Notice of Modification

Section 75W of the *Environmental Planning and Assessment Act 1979*

The project approval (MP 10_0046) granted by the Planning Assessment Commission, as delegate for the Minister for Planning and Infrastructure, for the NRE No. 1 Colliery Preliminary Works Project on 13 October 2011.

APPENDIX 2: PROJECT LAYOUT PLAN

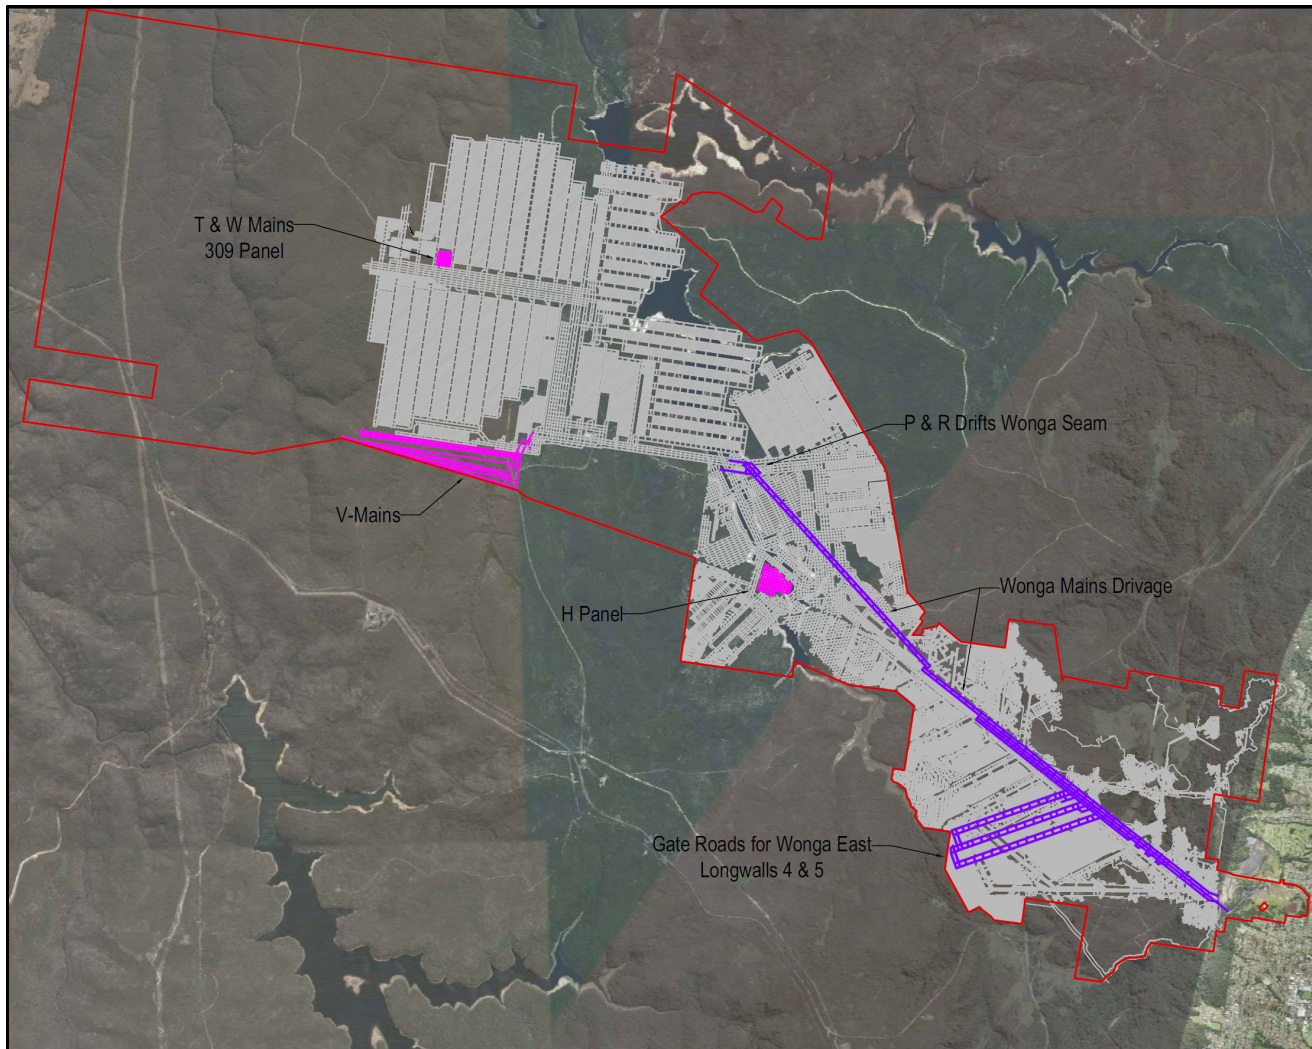
15. In Appendix 2: Project Layout Plan, delete the existing plan and replace with the following plan:
